| DRB A | pplication N | lo.:02-01762 (SBP) Project # 1002354 |
| Projec | t Name: ME | RIDIAN BUSINESS PARK EPC Application No.: Z-92-57 |

D.R.B. CASE NO.: 1002354 DATE: 11/27/02 ITEM NO.: 5

REQUEST FOR: Site Plan for BP.

SHEET SP-1

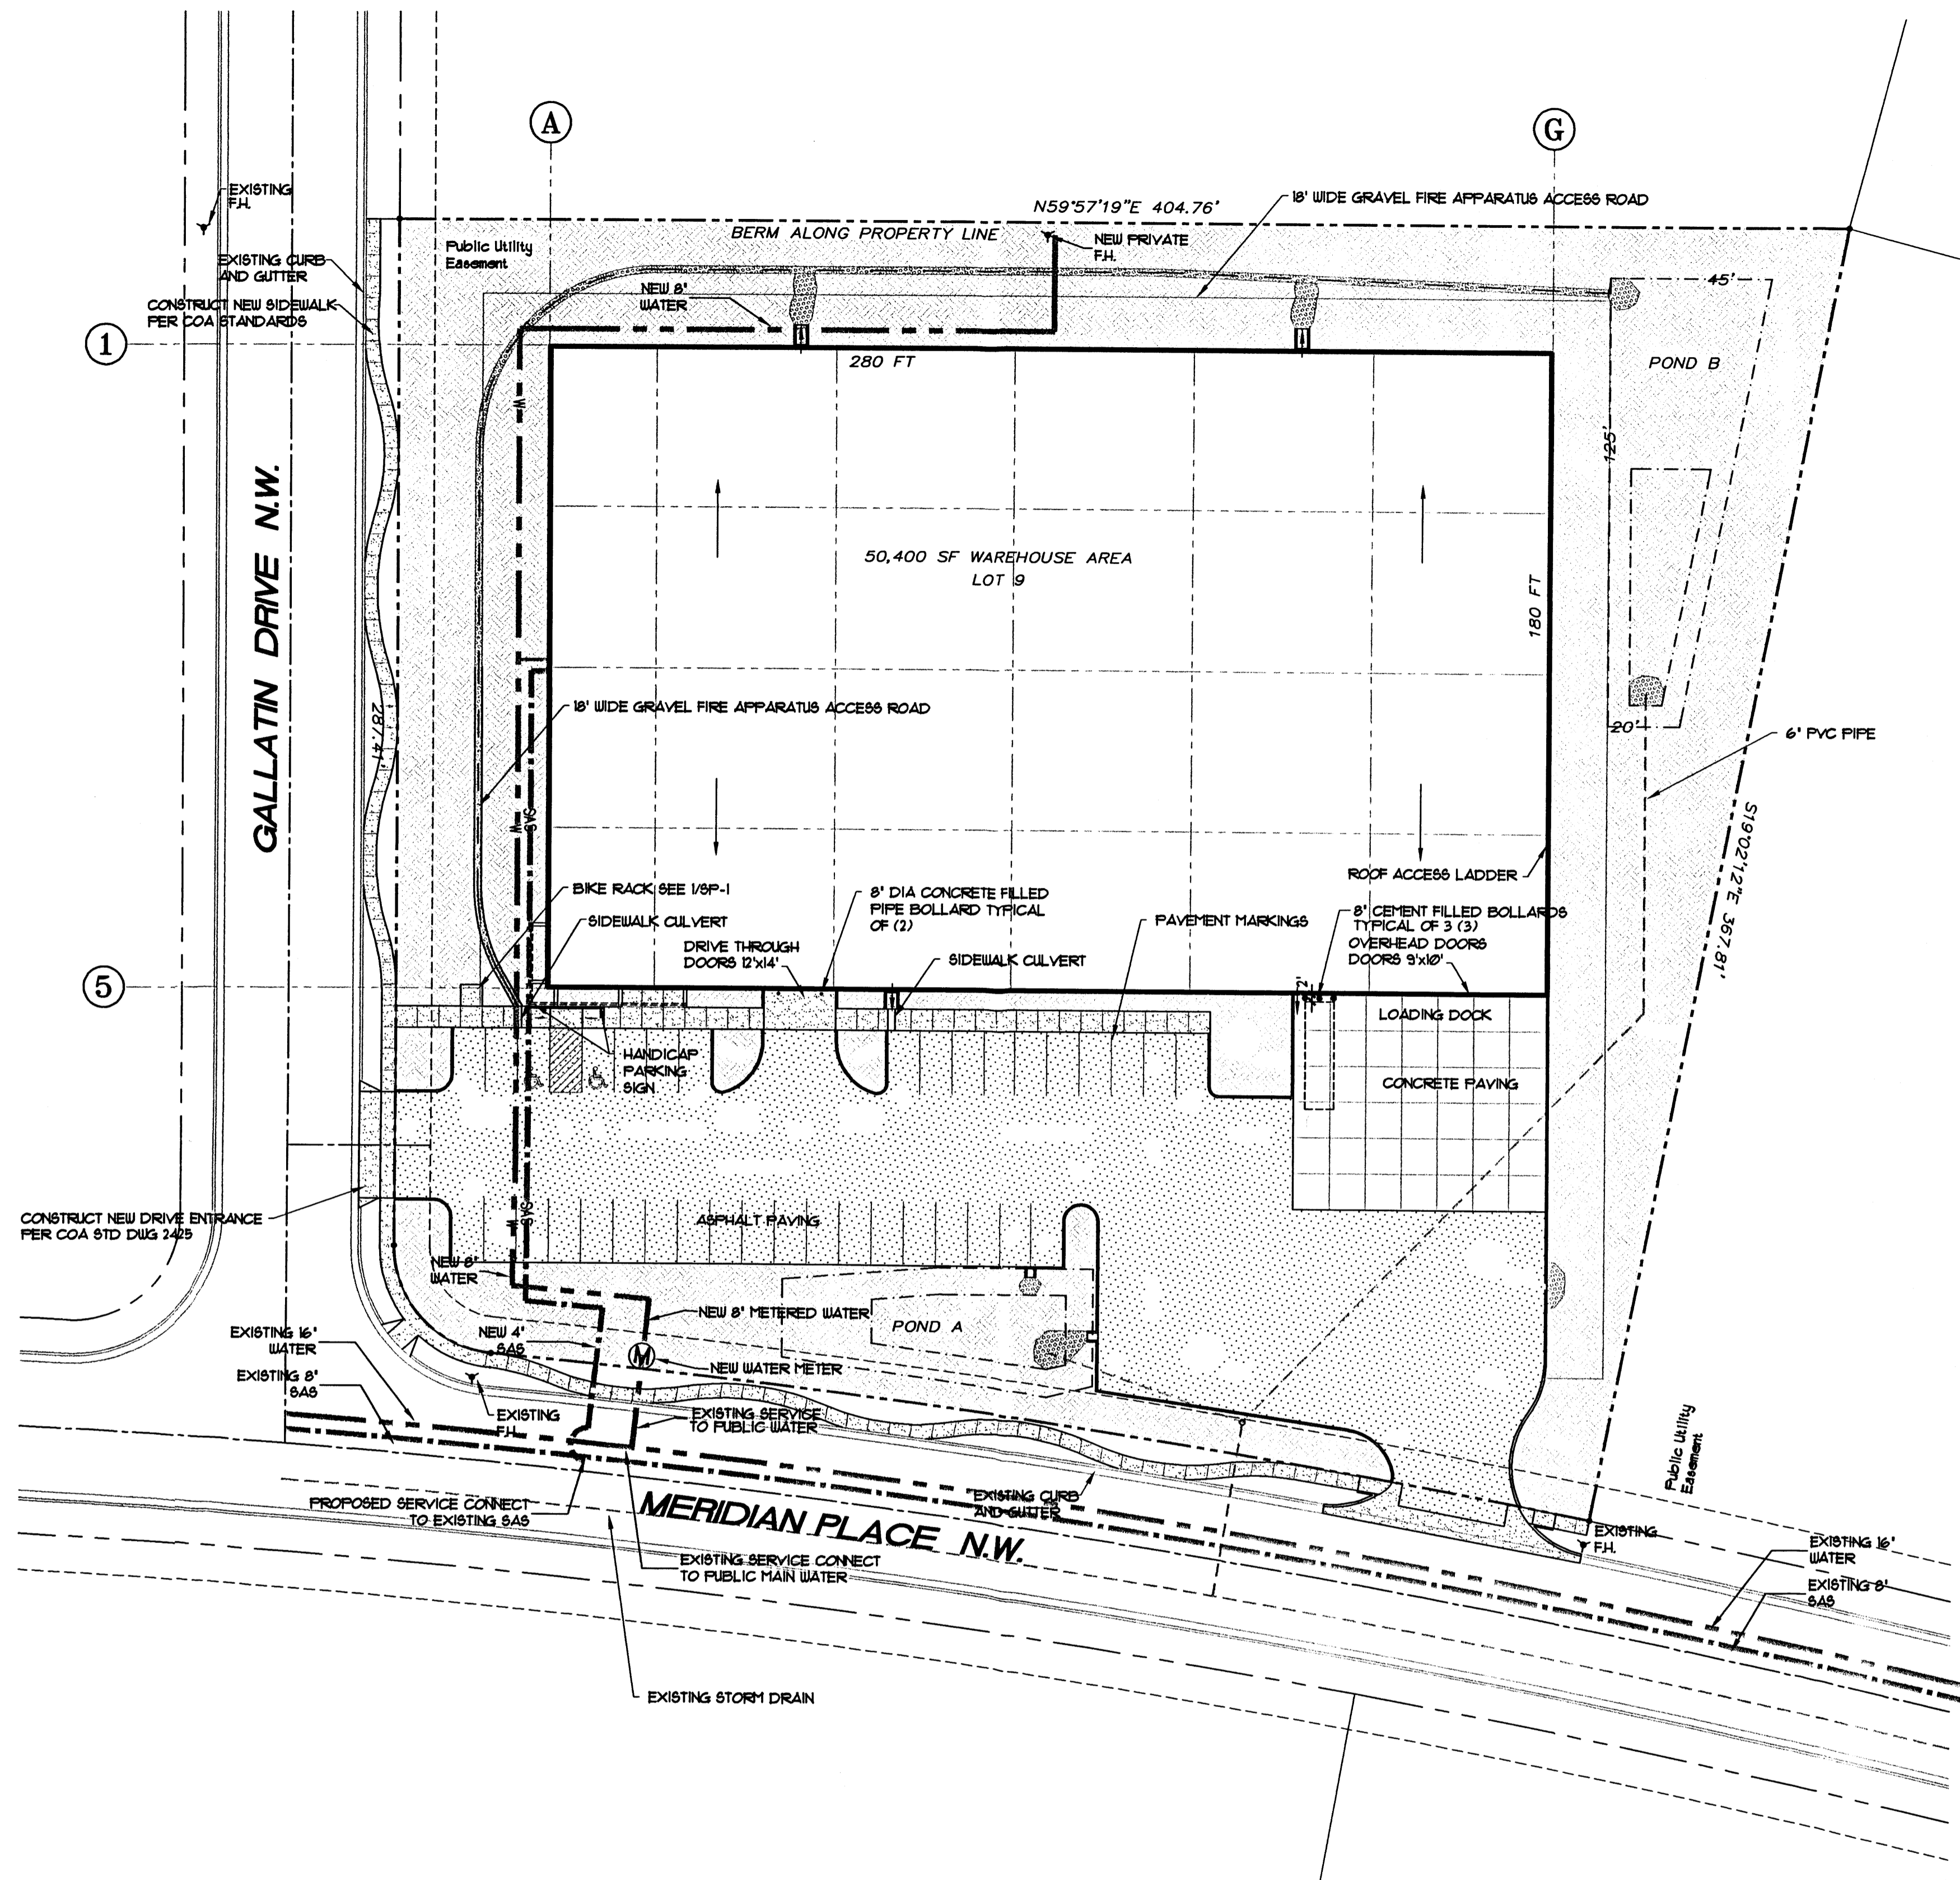
- 1. Plan calls for 8" meter.

UEC 8-inch meter = \$161k
- 3. Why the long waterline men to the FH C real of bulling" W in Gallatin is available for feeline connection.

Cikewise N SAS SVC: why not connect to Ck. 8" SAS in Gallatin?
- 3. Ex. W in Meridian Place is 10-inch, Not 16-inch as your plan shows.
- 4. Need protection for Fit @ rem of bldg.

Landscape Plan: Avoid high water use trees and high allergen junipers. The SDP shows landscaping in the same area as the "18' wide gravel fire apparatus access road". What is this? Vehicles can't travel in landscaping as shown.

Under Section 14-16-3-1, Parking Regulations, Part 3. General Regulations, of the City Zoning Code, G(4) "Where building facades abut parking areas, pedestrian sidewalks, no less that 8' in width, shall be provided adjacent to and along the full length of the building.

Screening for refuse receptacle: The Meridian Business Park Plan indicates a 6' masonry enclosure. The SDP does not clearly indicate if and what type of screen enclosure is planned. Please indicate with a statement or elevation cross section on the SDP.

ELEVATIONS

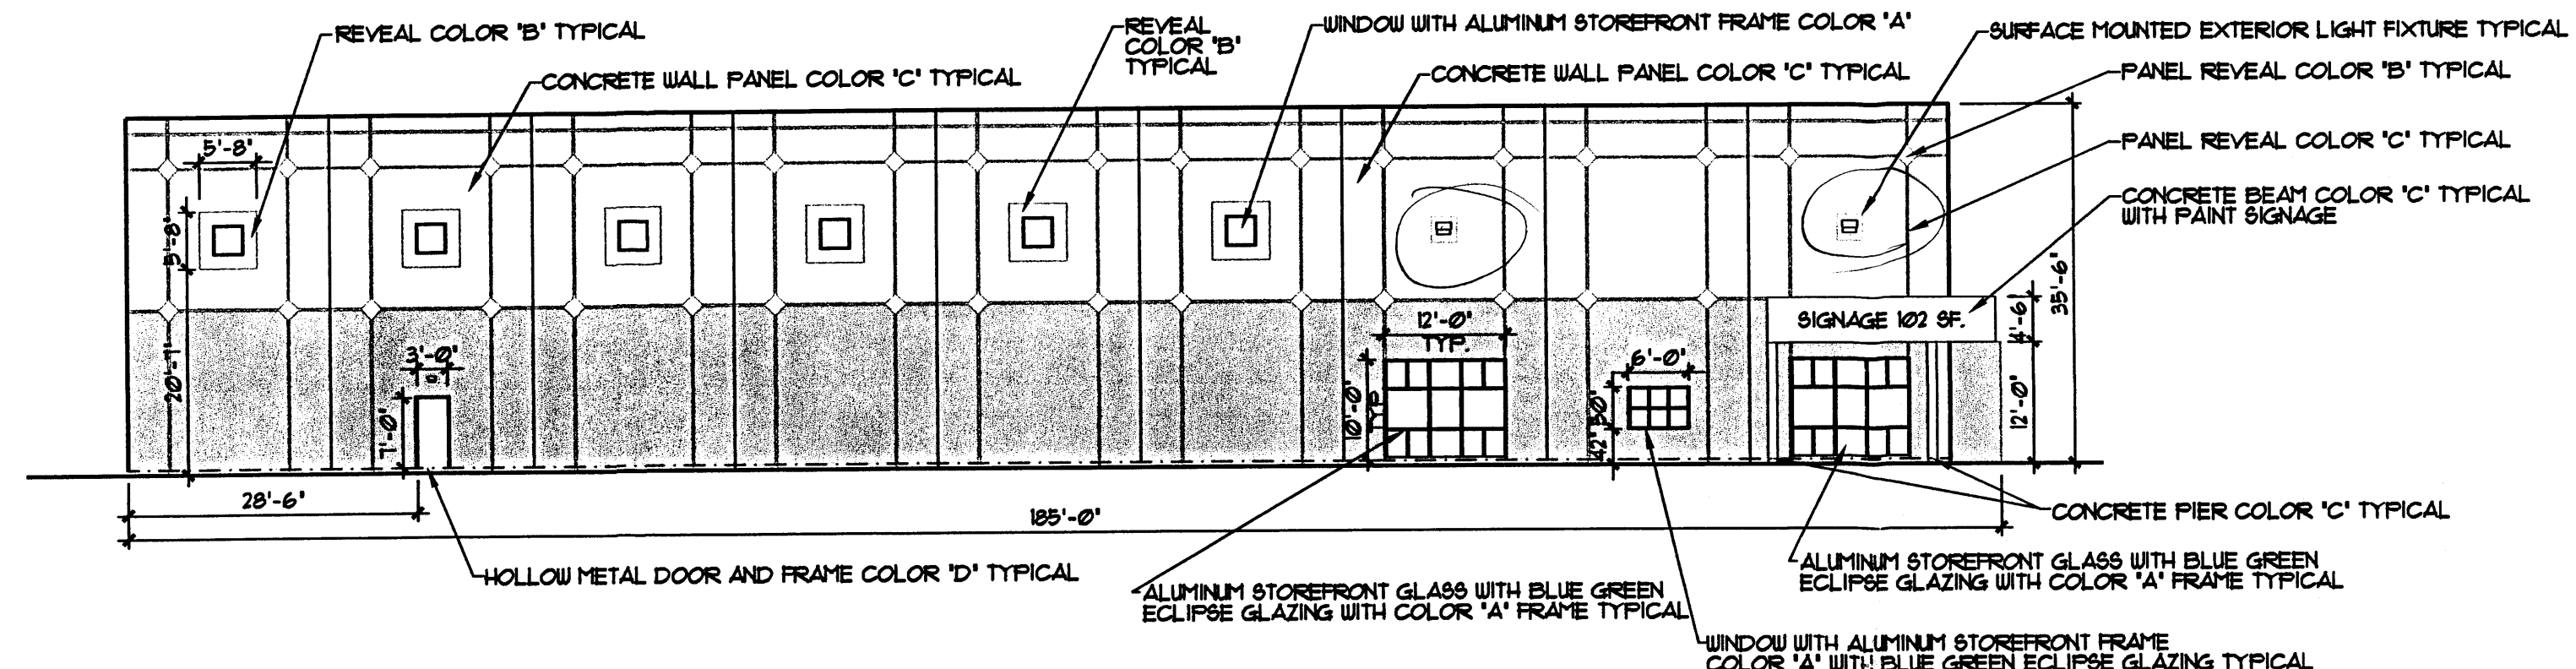
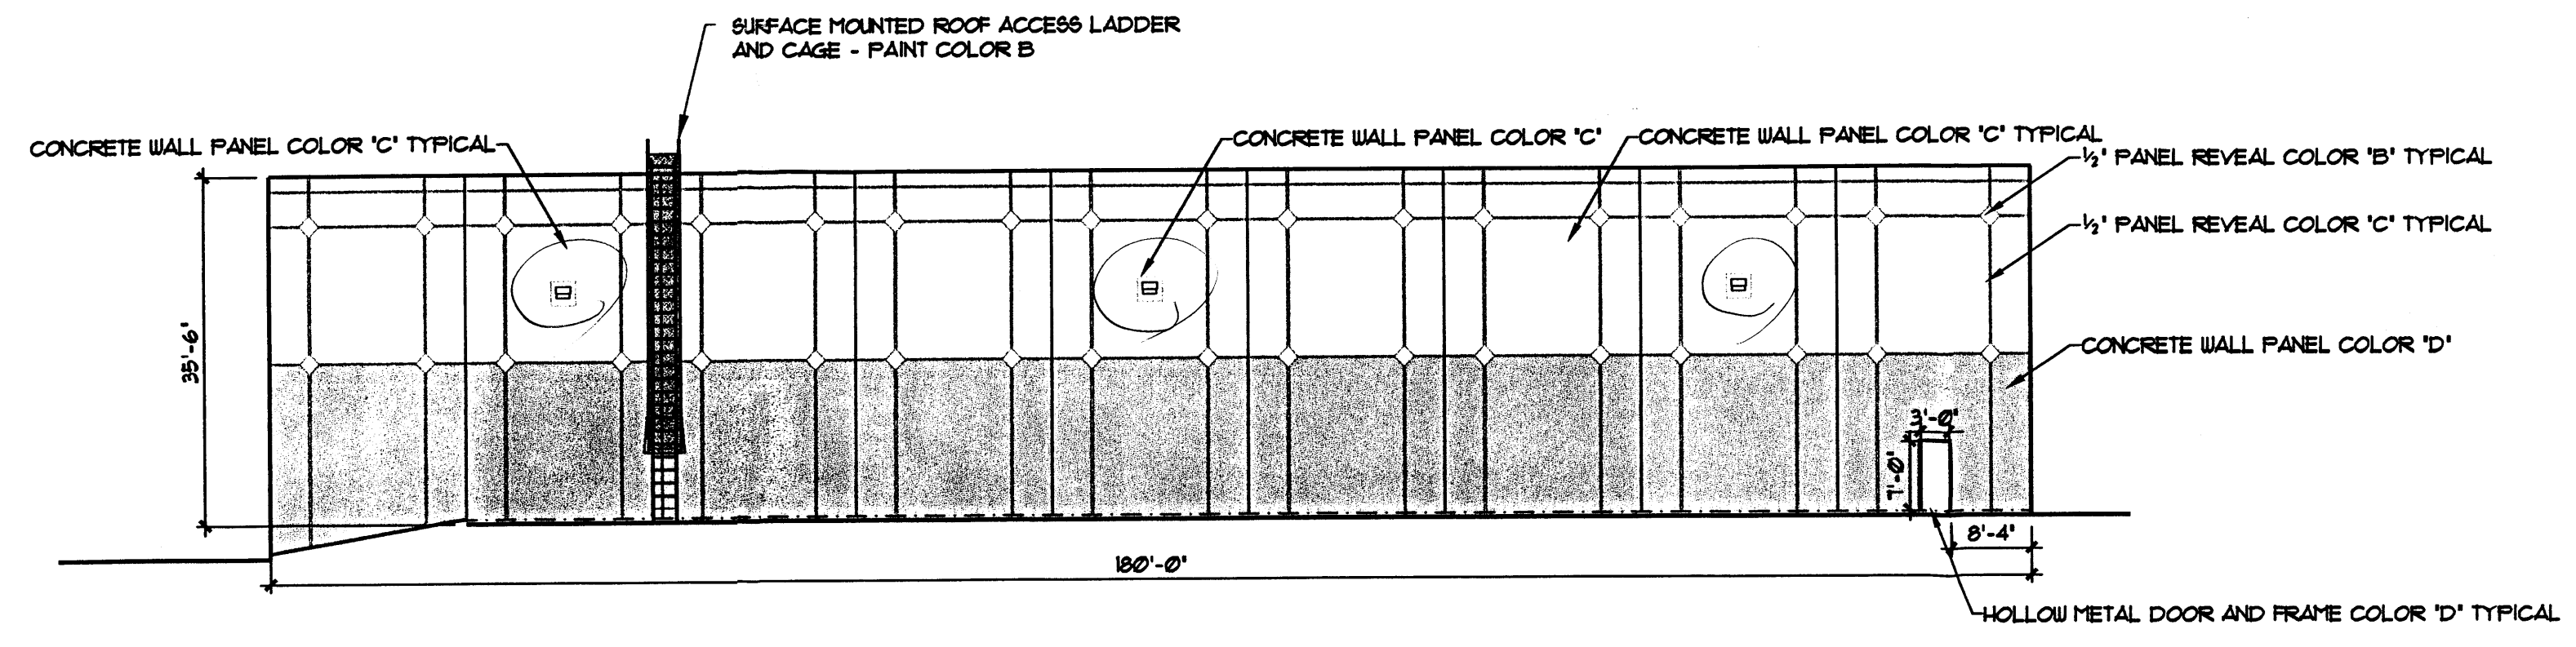
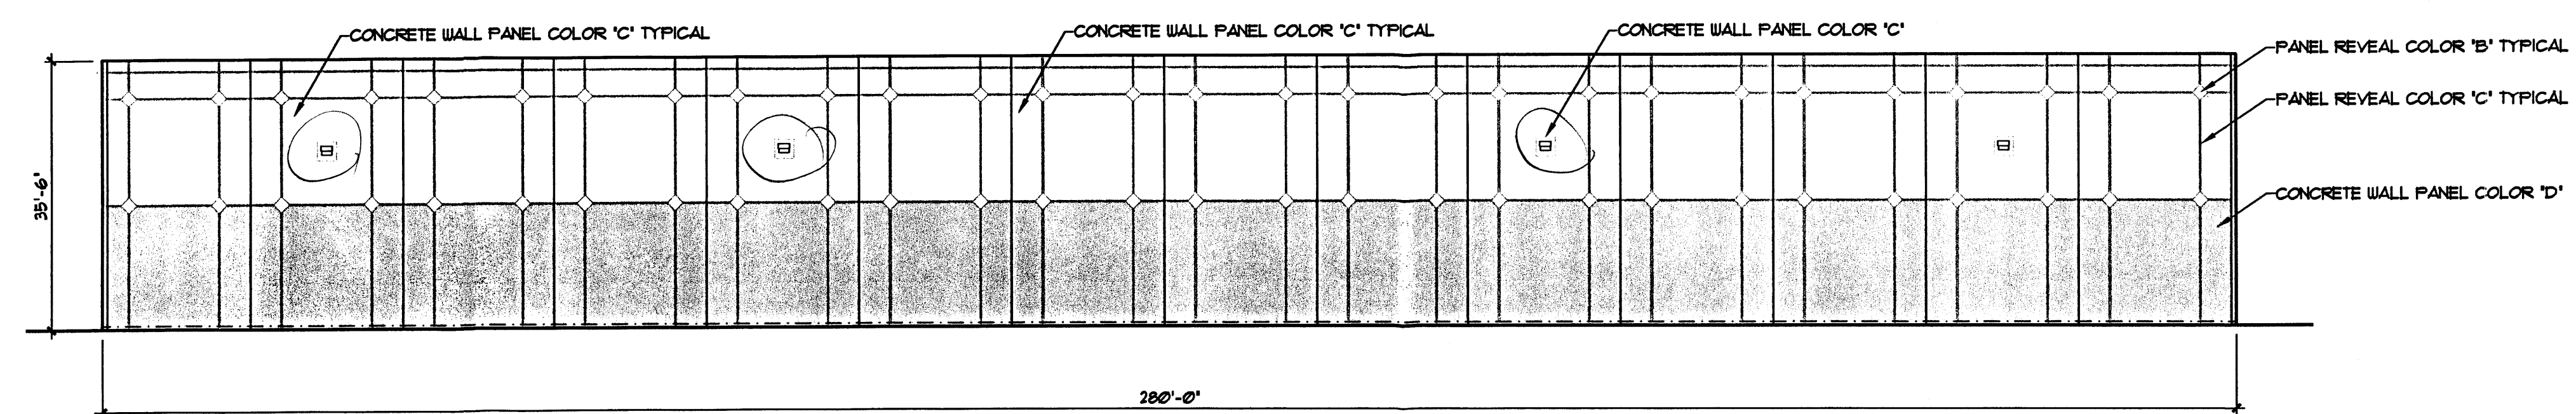
The signage on the front building elevation is unclear as to face height & width dimensions. Please indicate also the sign color & material, Whether it will be illuminated and if so, how per Atrisco Business Park MDP.

2. Lighting: The density is required on the Elevations Sheet. Parking lot lighting is not indicated. Height, type, density & location is needed per City Zoning Code, Section 14-16-3-9.
